Subdivision Name: Franciscan Acres - Lots 6A1 & 6A2 Block 10A

DRB Application No.: **04DRB-00561 (P&F)**

**CITY OF ALBUQUERQUE
PLANNING DEPARTMENT
Development Review Board
April 221, 2004
Comments**

RE: Franciscan Acres/minor plat

**LOTS 6-A-1 AND 6-A-2
 BLOCK 10-A
 FRANCISCAN ACRES**
 (BEING A REPLAT OF LOT 6-A, BLOCK 10-A, FRANCISCAN ACRES)
 SITUATE WITHIN THE TOWN OF ALBUQUERQUE GRANT
 IN PROJECTED SECTION 8, TOWNSHIP 10 NORTH, RANGE 3 EAST, N.M.P.M.
 CITY OF ALBUQUERQUE
 BERNALILLO COUNTY, NEW MEXICO

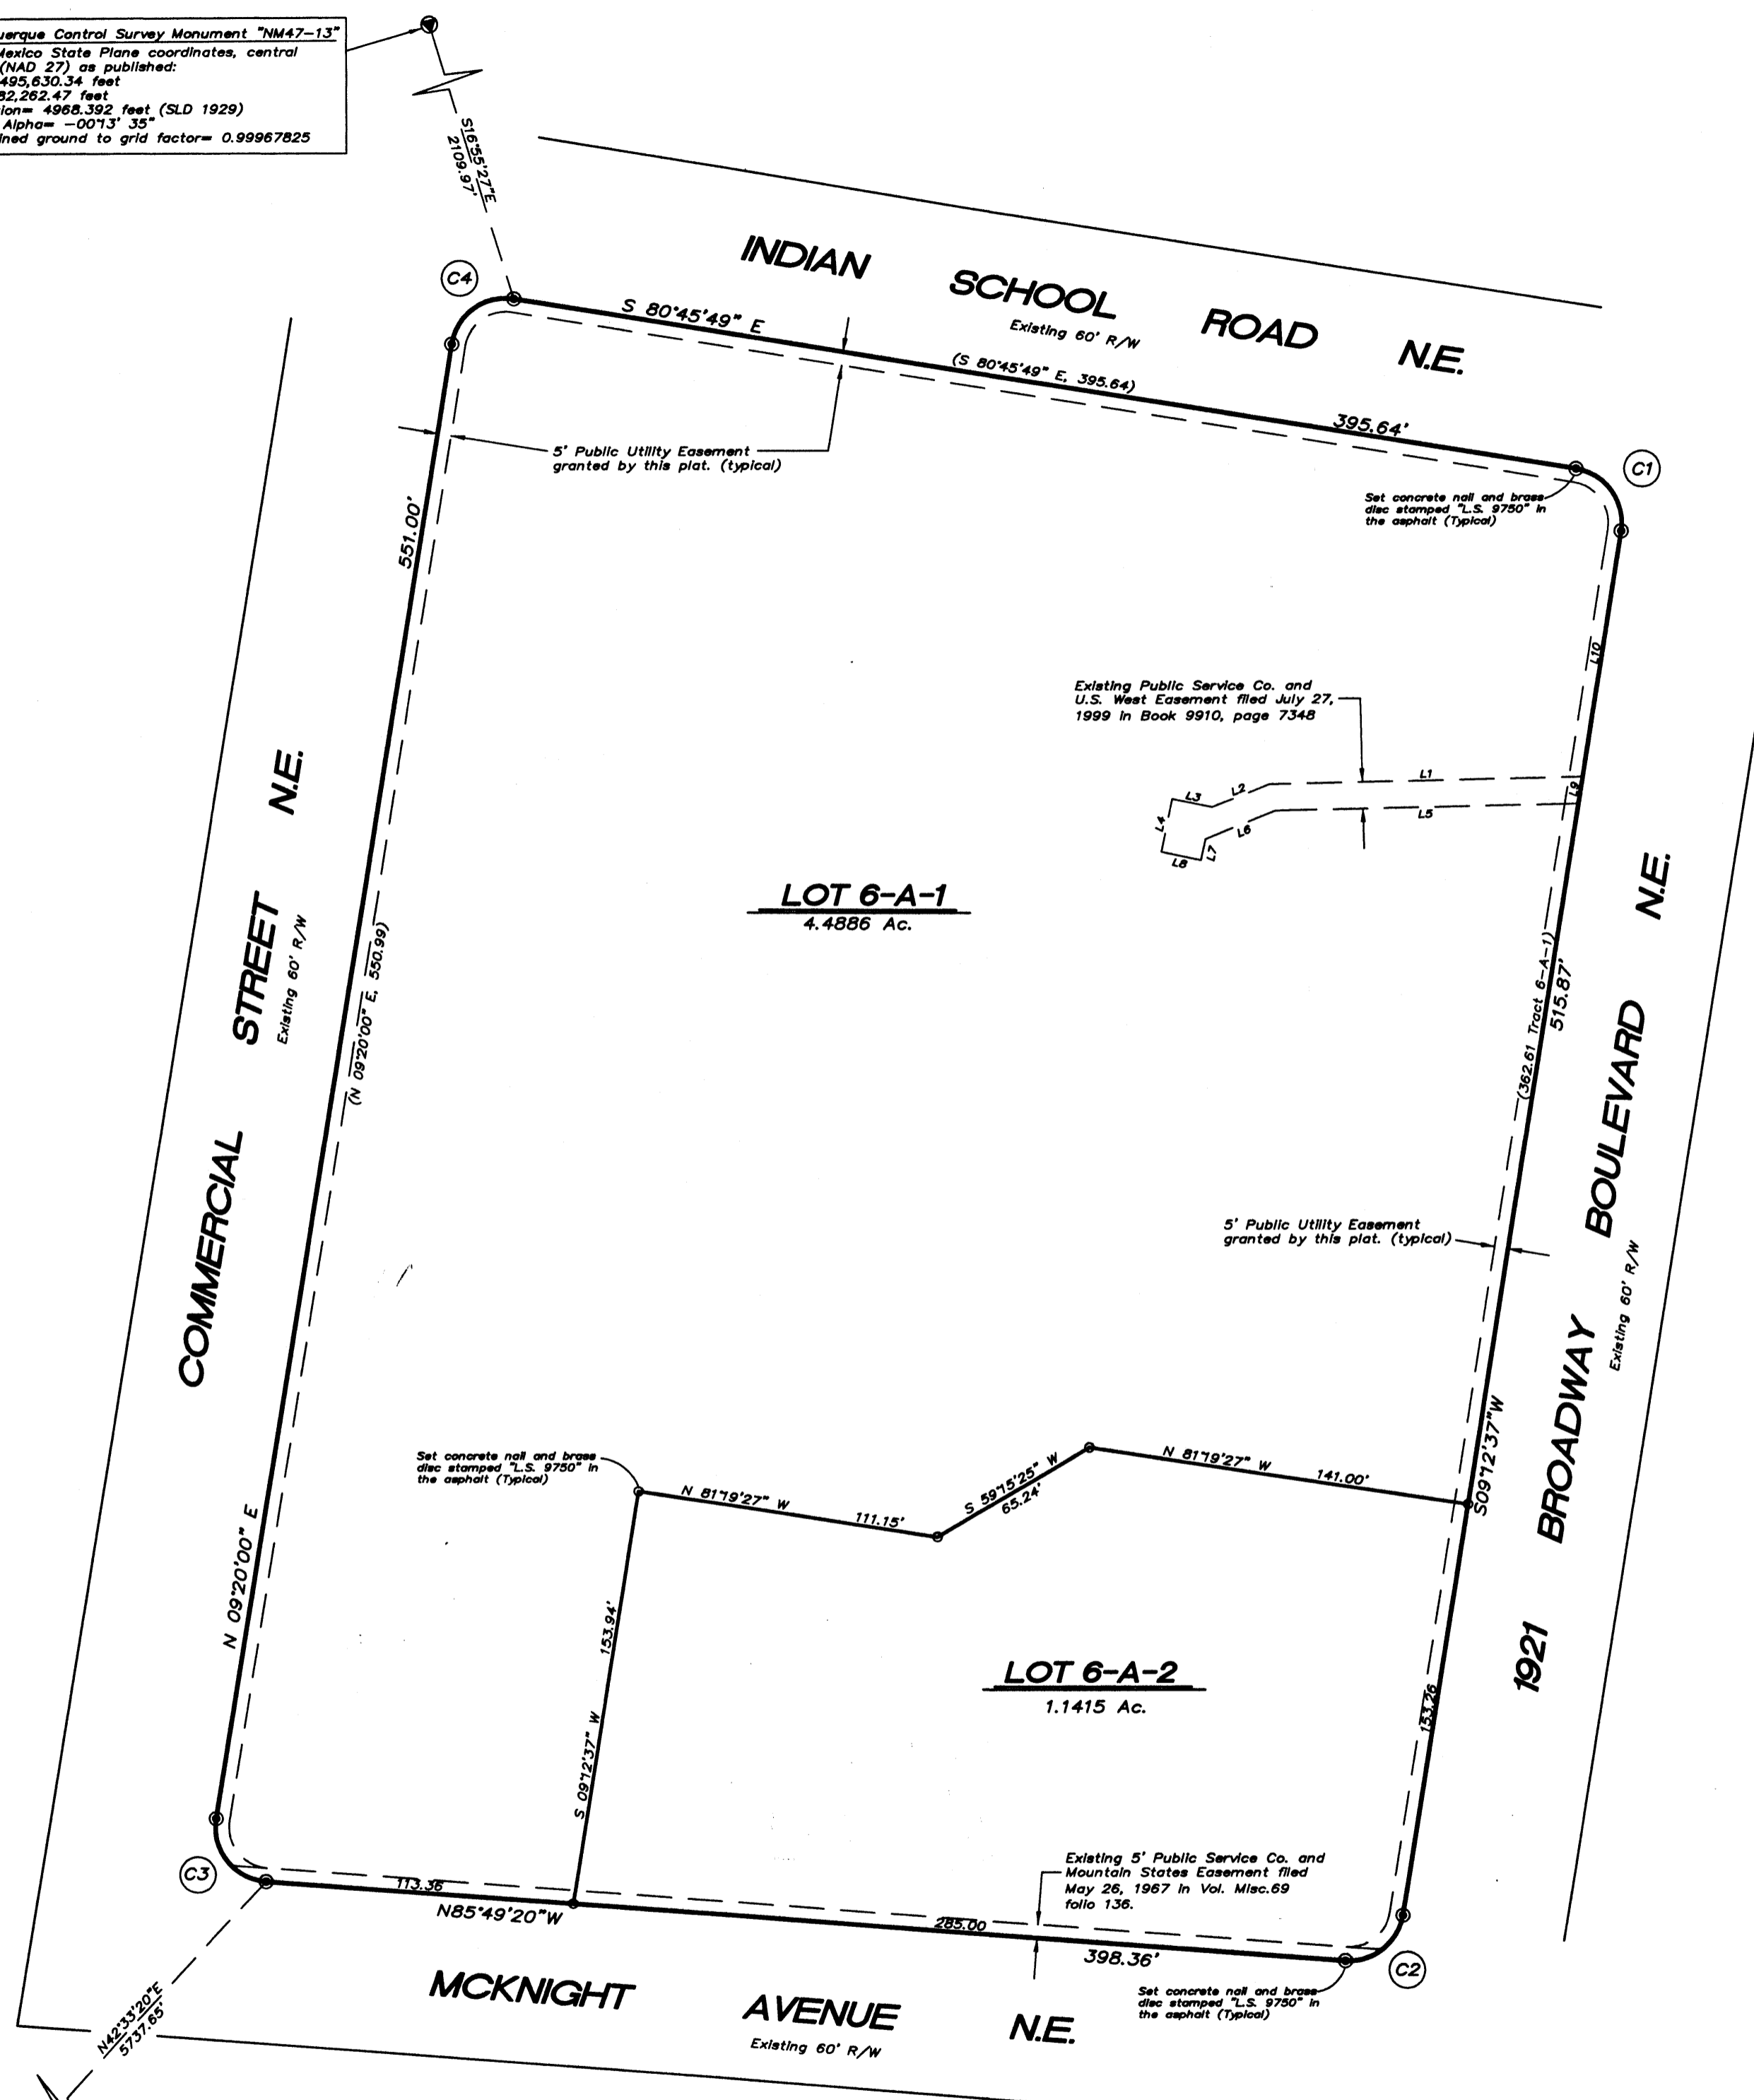
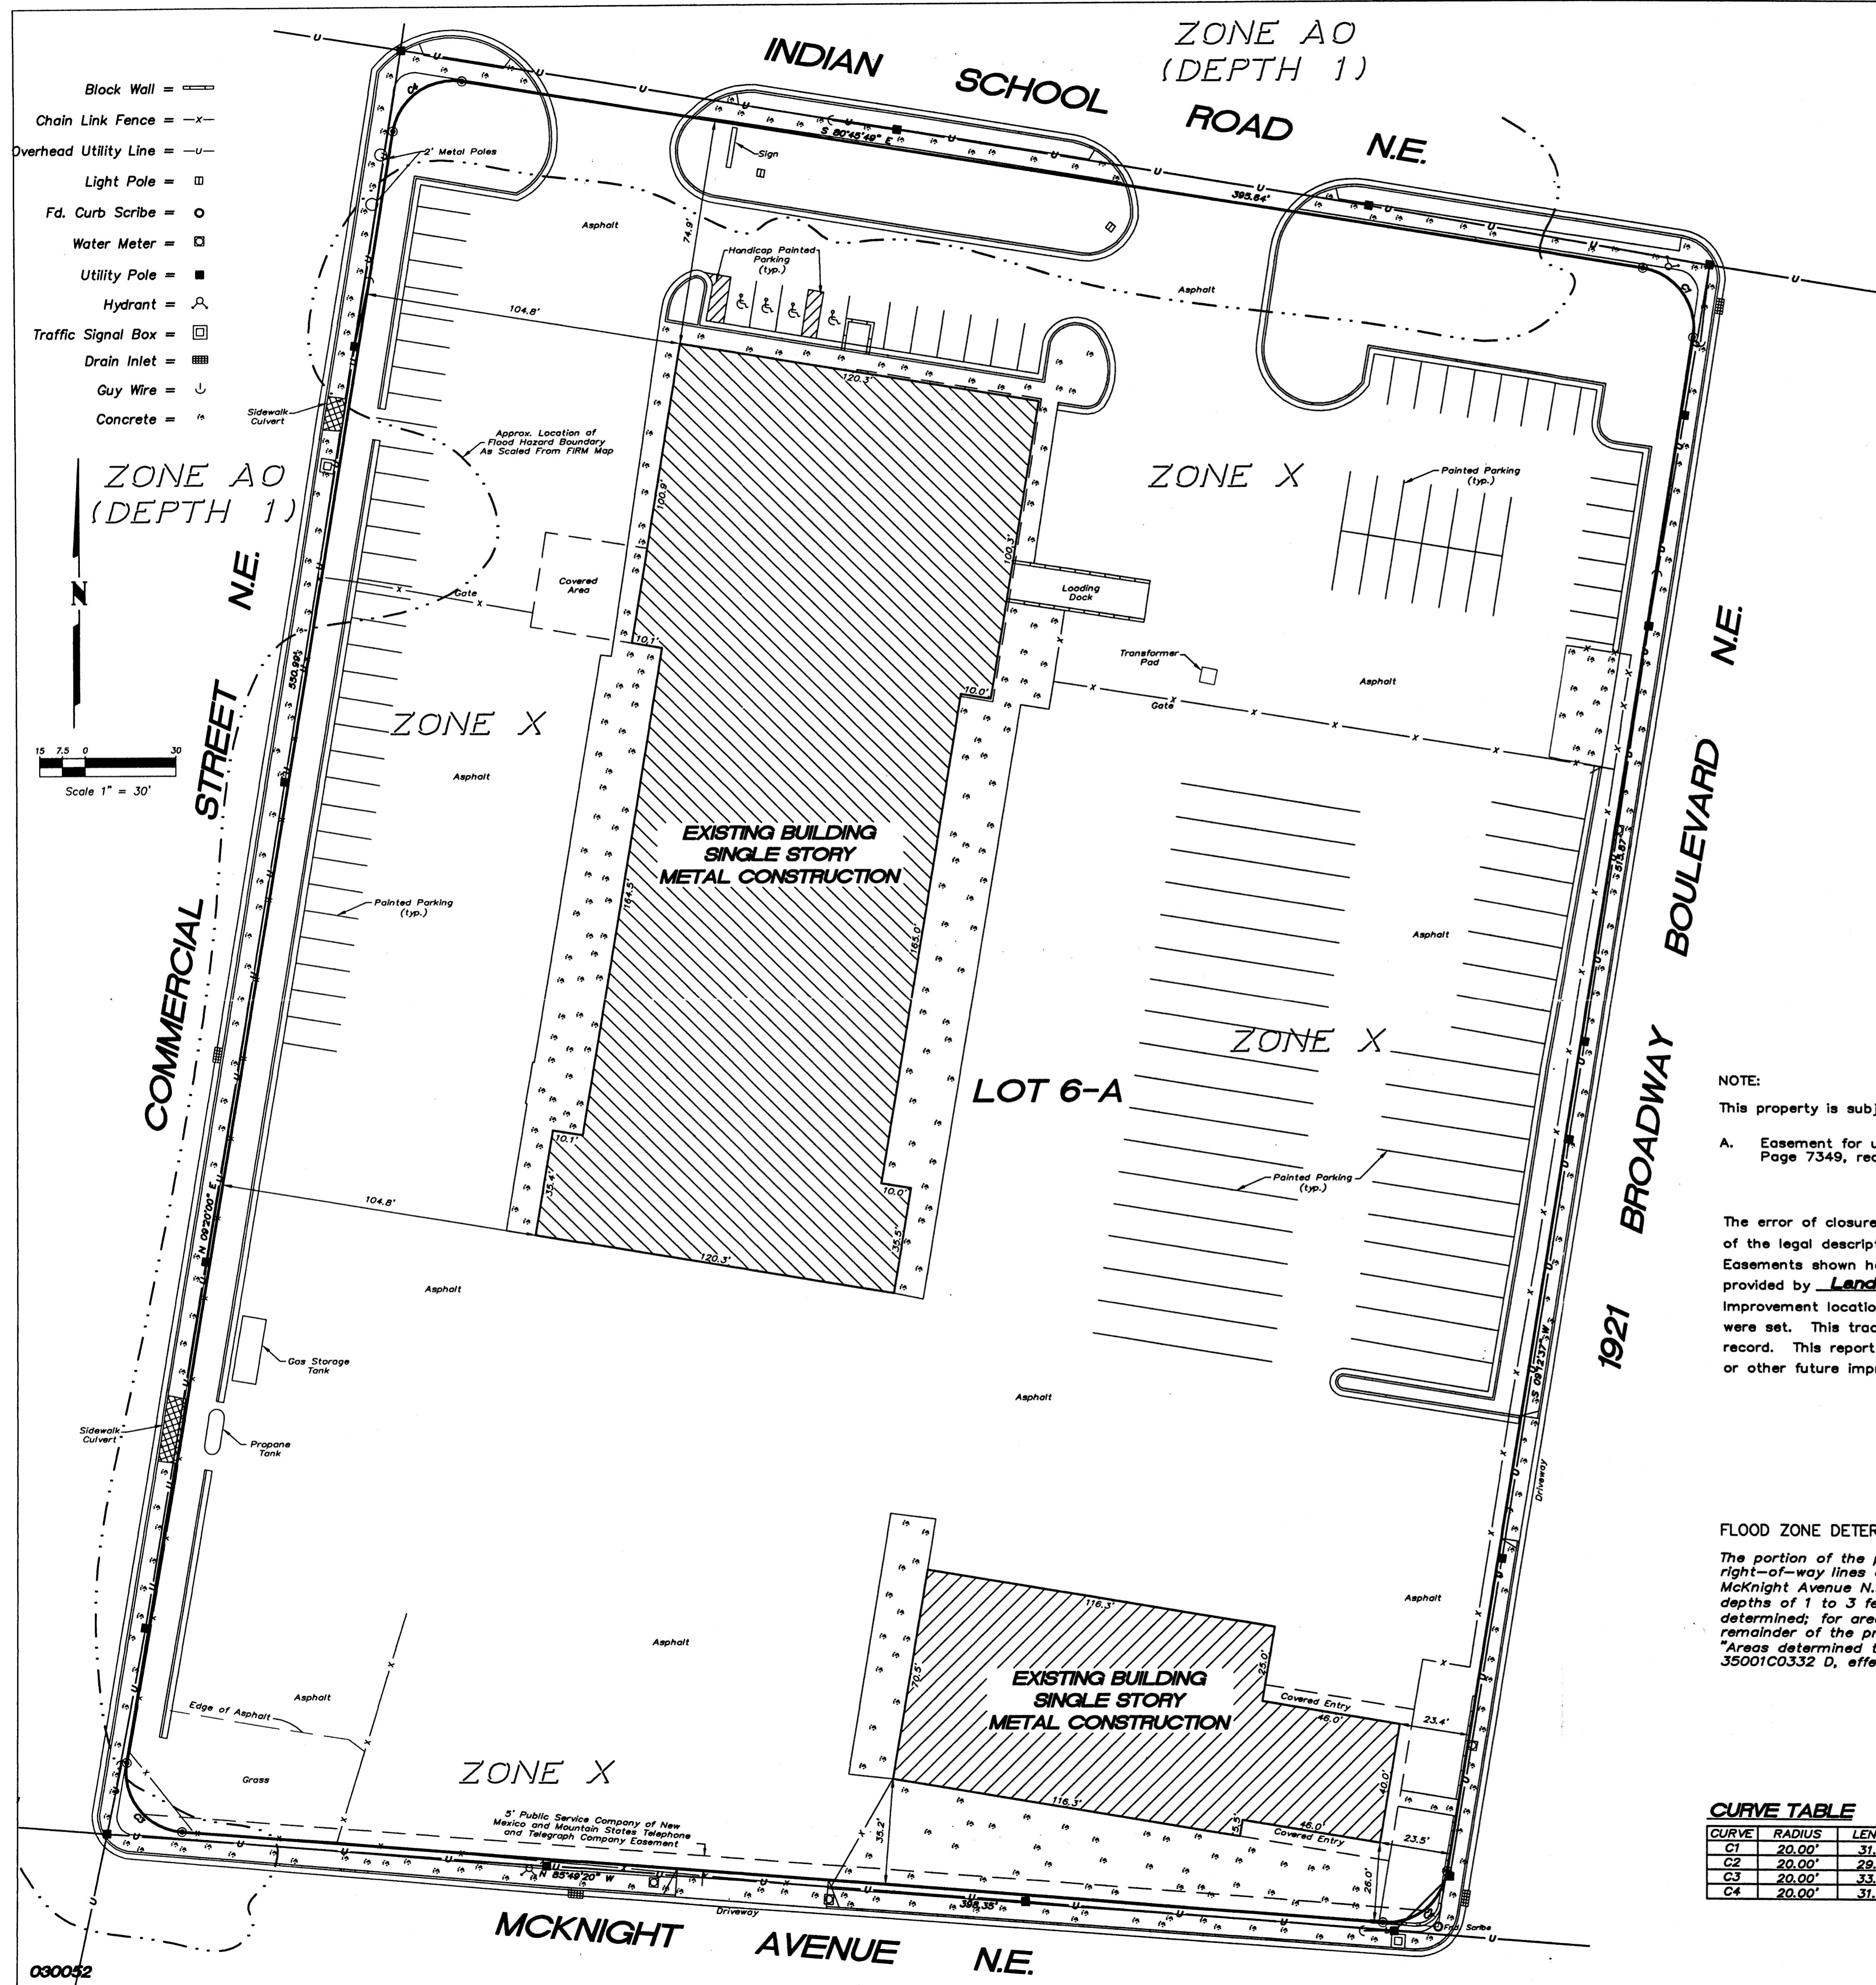
- ✓ The zoning should appear on the plat under General Notes per the Subdivision Ordinance.
- ✓ The title "Chief Financial Officer" should appear on the plat below Mr. Sparks' signature.
- ✓ The property lies within the Martineztown Santa Barbara Sector Plan boundaries. The zoning follows the Zone Code M1 zoning requirements. As a result, there are no minimum lot sizes for this zoning.

- 1) Broadway is a Principal Arterial (124' right-of-way).
- 2) Indian School requires bikelanes.
- 3) McKnight is a bikeroute.
- 4) Provide sketches of x-sections. Need dedications 9' face of curb to property line. Dedications also need to be evaluated against bike criteria.
- 5) Need to maintain clear sight for entrances. Are any new curb cuts proposed?
